Engineers Comments Regarding Surface Water Drainage

Application Reference:	M/39/24/DOC	Reviewer Reference:	ADC/PC
Planning Officer:	Kathryn Welch	Date of Review:	03/09/2024
Site Name:	117 Elmer Road Middleton-on-Sea PO22 6LH		
Application Description:	Approval of details reserved by condition imposed under reference M/84/23/PL relating to condition number 7 - surface water drainage scheme.		
Assessment Number:	1 of 2

Condition 7: **Further information required**

SURFACE WATER DRAINAGE PLAN

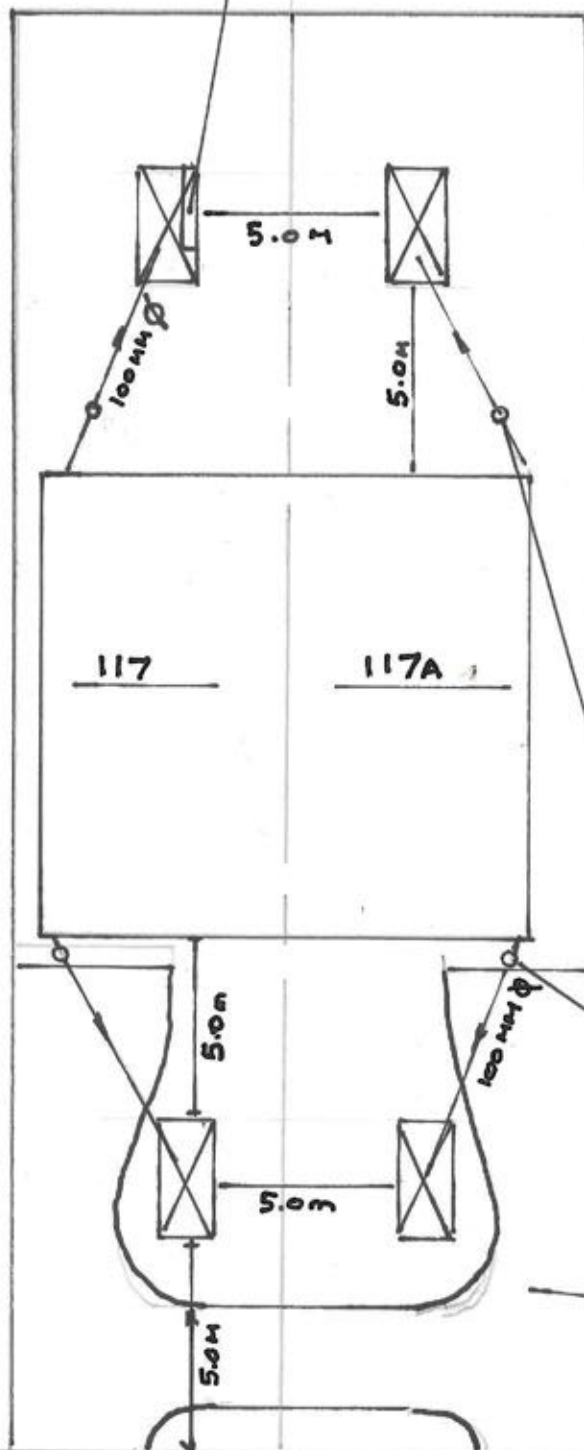
1.	Calculations should be based upon FEH rainfall data. (Currently FSR).	Thank you – point closed.			
2.	The proposed soakaways appear to be undersized. The calculations specify a total volume of 6.28m ² per housing unit. The layout shows a total volume of 2.28m ³ per unit (split between two soakaways, one at the front and one at the rear).	Thank you – point closed.

3.	The soakaways at the front of the proposed properties are positioned too close together, ideally these should be 5m apart.	Thank you – described in method but not shown clearly on the layout. Please mark.	Thank you – point closed.

4.	Please provide catchpits/silt traps upstream of all soakaways.	Thank you – point closed.			
5.	The drainage layout requires further detail. Please see guidance note k on the attached drainage checklist for the level of detail required.	Soakaways need to be labelled with base levels and cover levels. Silt traps (which will also be inspection chambers) need to be labelled with cover levels and pipe invert levels. The invert level of '300' given for the soakaways is unclear if it relates to the incoming pipe invert level – which we need, or the base of the soakaway. It is unclear what the 300 relates to, mm below ground level?	Please see points 10 and 11 below regarding 'levels' vs 'depths below ground level' and the risk involved with this descriptor.

7.	Please ensure that your drainage layout clearly indicates that soakaways are positioned 5m from the proposed properties.	Thank you – point closed.

117 ELHERO Sockaway Section
 Sockaway size 3.0m x 1.8m x 0.84m

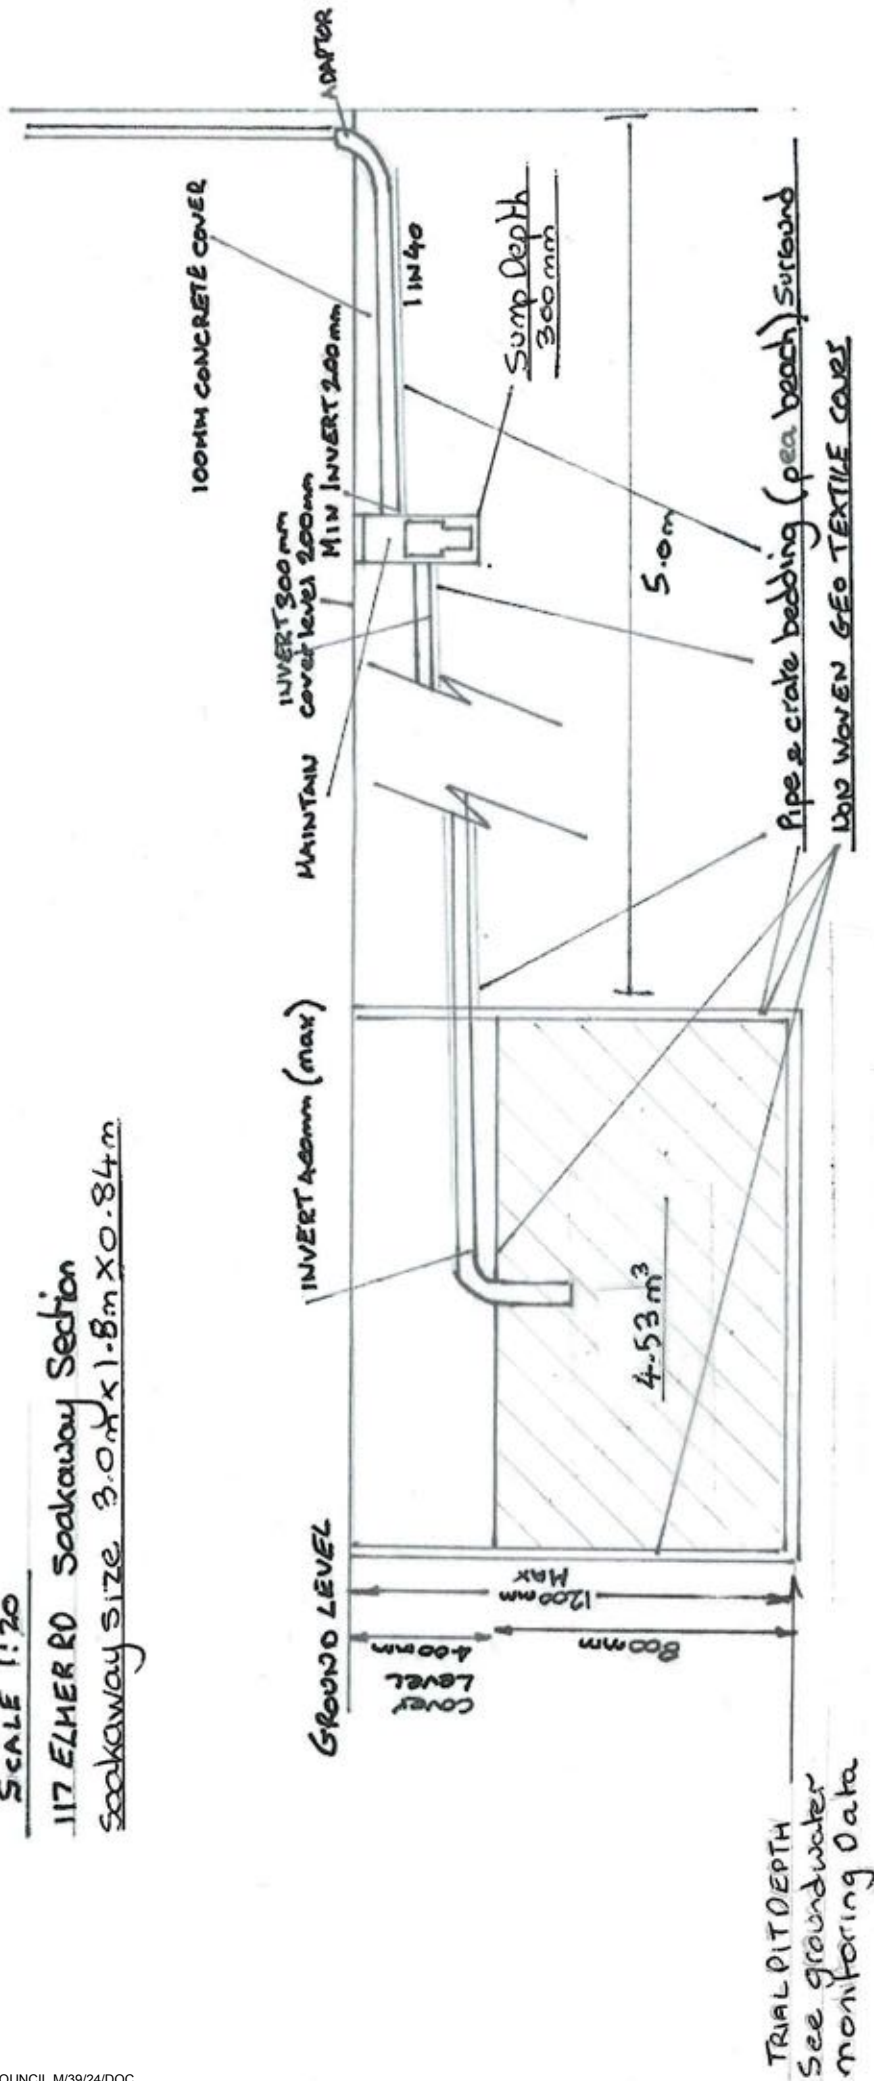
9.			The soakaways dimensions in the calculations do not reflect the soakaways that are proposed on the layout and section. Please submit revised calculations.

10.			Please stipulate the gradient of the pipe between the silt trap and the soakaway on the soakaway section drawing, ensuring that the calculated pipe invert levels reflect the gradient specified. The current drawing assumes level ground, however, if the ground is not level, then basing the design drawings only on dimensions below ground level can risk an inaccurate pipe gradients/pipe invert levels and soakaway base/cover levels. Please clarify if the ground is level and adjust the design as necessary.

11.			The cover level of the soakaway is likely to be more than 400mm depth below ground level to achieve a 1 in 40 gradient for the length of pipe proposed. Please adjust the design as necessary. Please specify the distance of the vertical pipe drop into the soakaway (from the top of the soakaway to the bottom of the pipe. [An alternative option is to have the incoming pipe at the side of the

soakaway into one of the likely prefabricated inlets. This will aid the designer in achieving the specified gradients without altering the depth of the soakaway, etc.]		
12.			Please provide fully detailed construction details for the silt traps.		
13.			Please specify that the non-woven geotextile is <u>permeable</u> and make it clear on the soakaway section that this is a full wrap around the crates, not just a cover.		
14.			Please specify the manufacturer and model of the crates being used, these need to be checked to ensure that they are capable of carrying the loads at the specified depth, particularly under the driveway.		
15.			Please specify the subbase material beneath the driveways stone filled grid, including its depth. [Natural ground is unlikely to support a vehicle. Please also note that Type 1 material will not be acceptable as a subbase since it is not permeable.]
